Your ref: 3/2013/0271
Our ref: DC/13/1347
Date: 19-APR-13

Location: Land at George Lane Read Lancashire
Proposal: Erection of two detached dwellings

Client JWPC		
Job Title Proposed development to Land at George Street Read		
Drawing Title Proposed Site Plan		
Scale 1:200@A1	Date August 2013	Drawn J Bowden

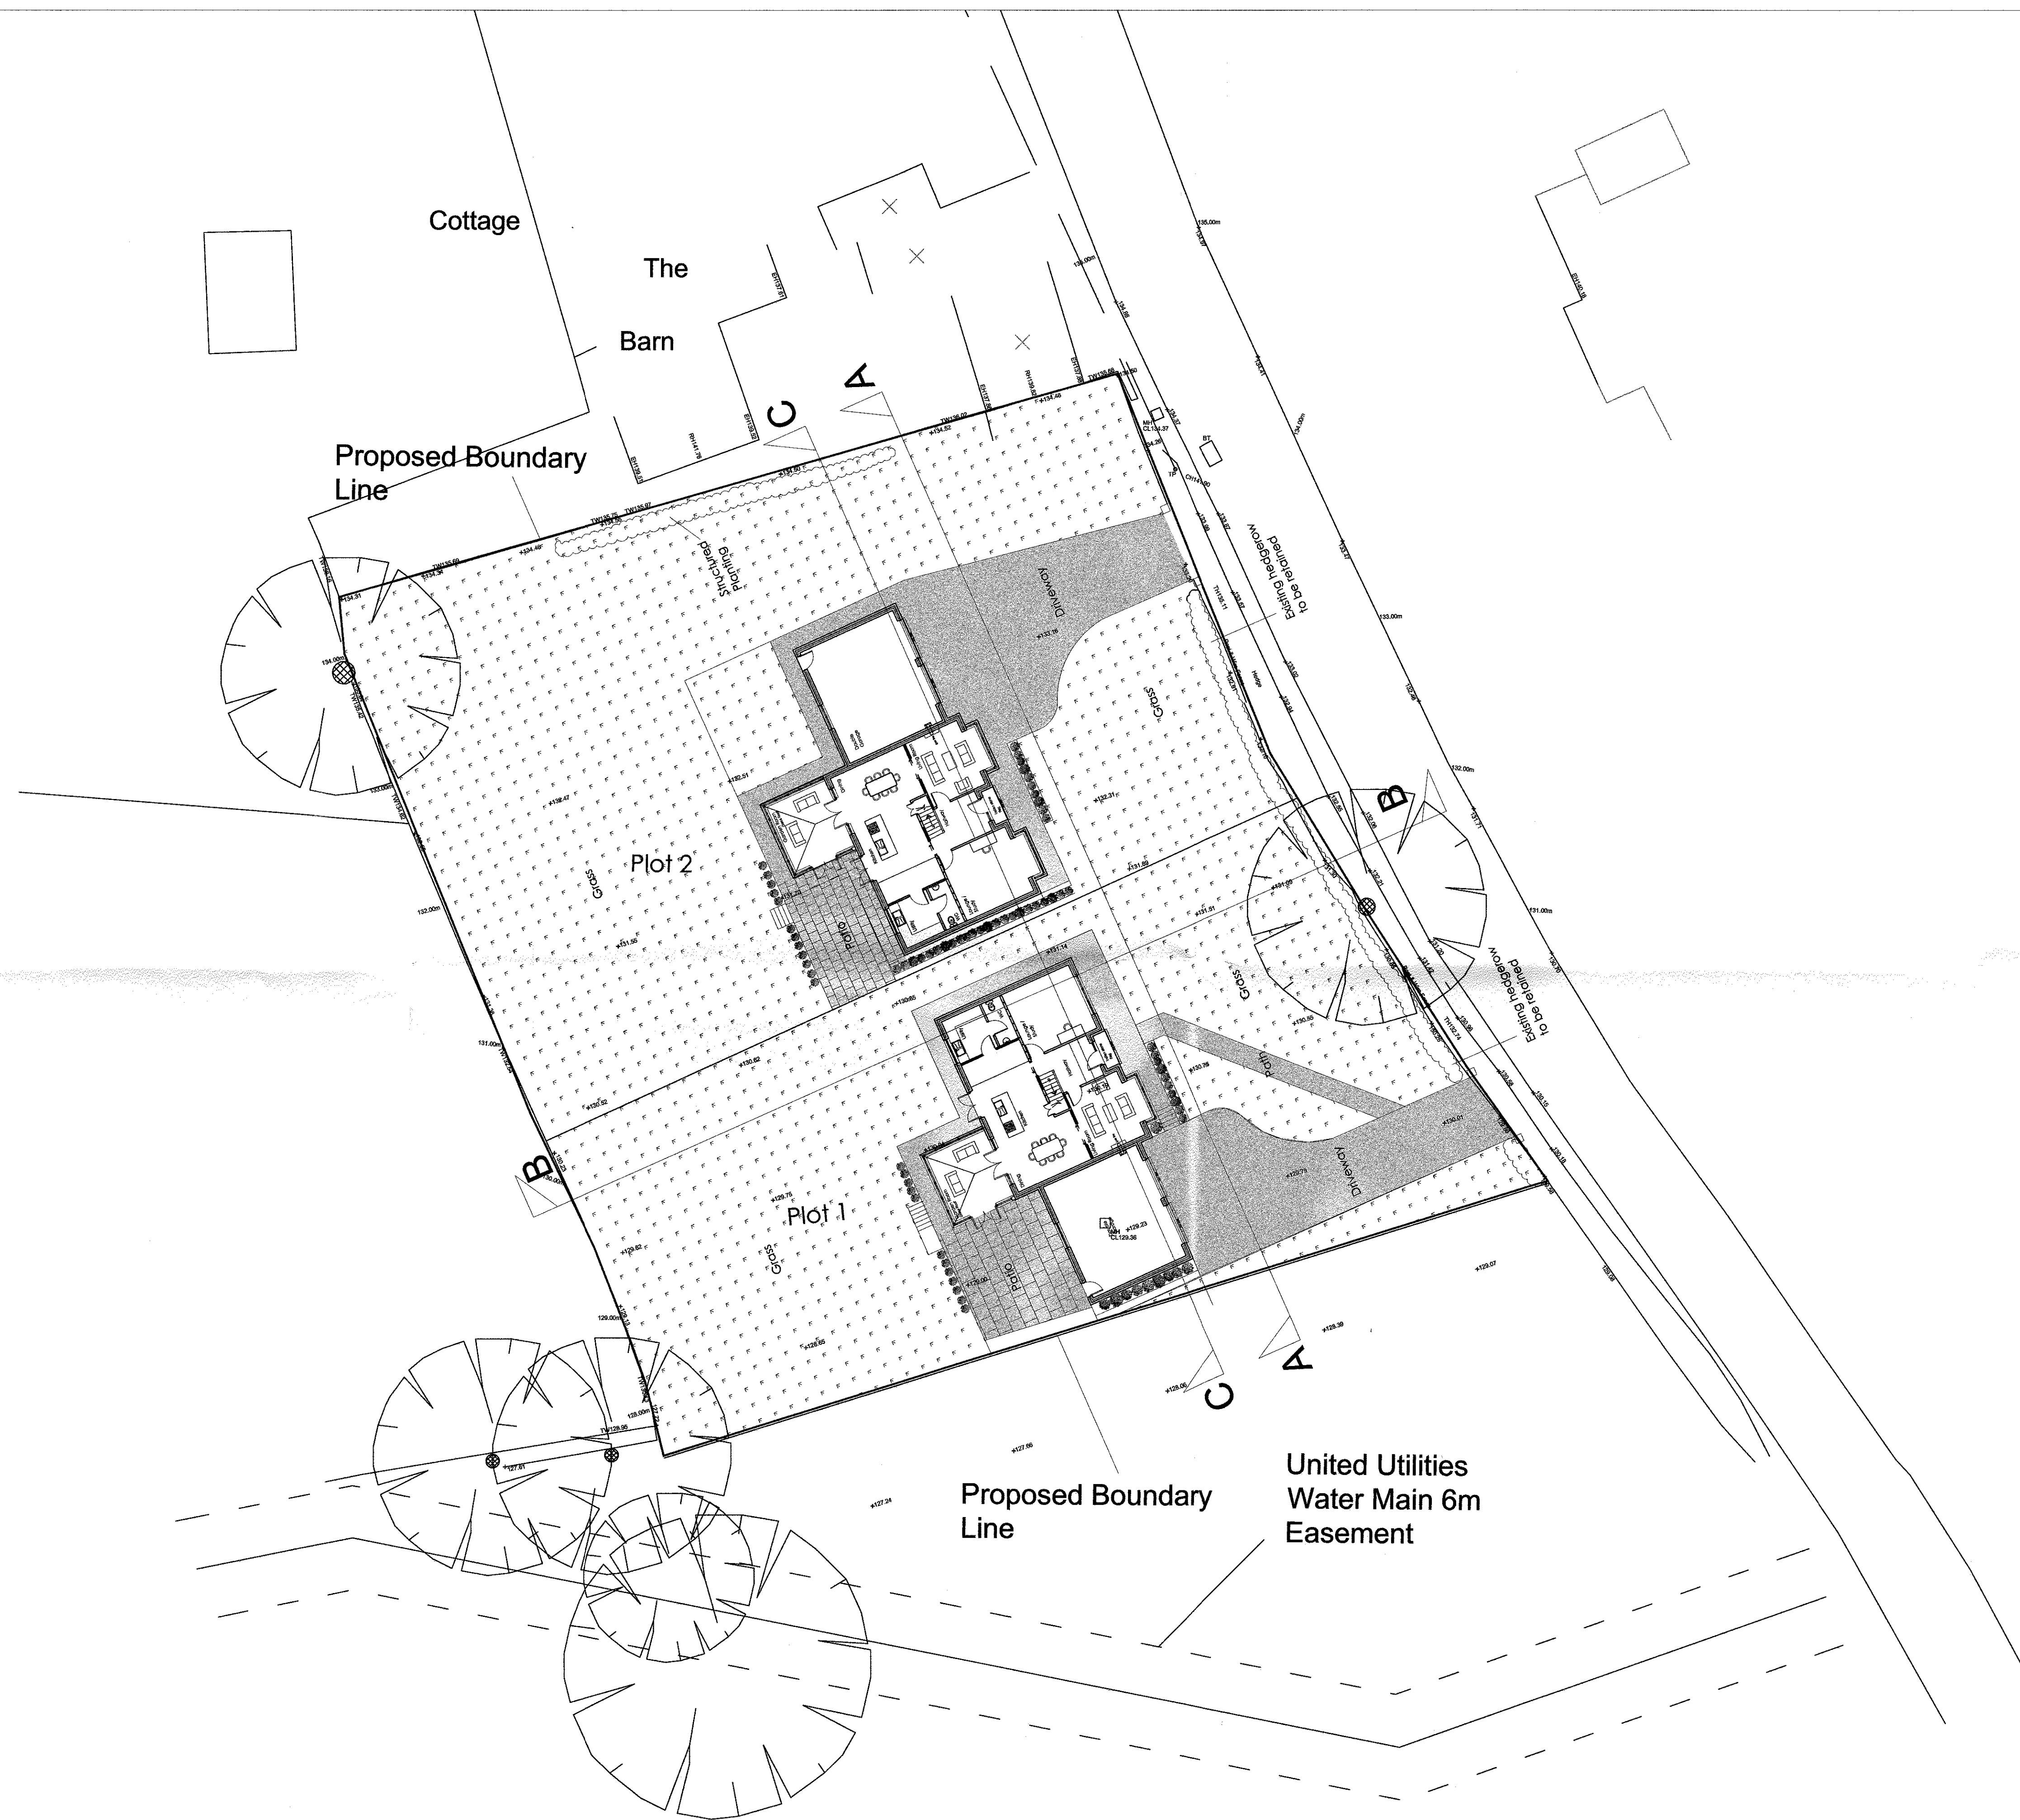
There is an easement slightly clipping the south west corner of the proposal. However from the building plans the only thing that would affect the pipe is the proposed trees which must not be planted in this area. Also the developer must be aware that no walls or fencing are to be erected over the easement strip as this could damage the pipe. I would advise that the water main is to be plotted accurately prior to any works carried out as I feel the location of the easement does not follow that of the pipeline.
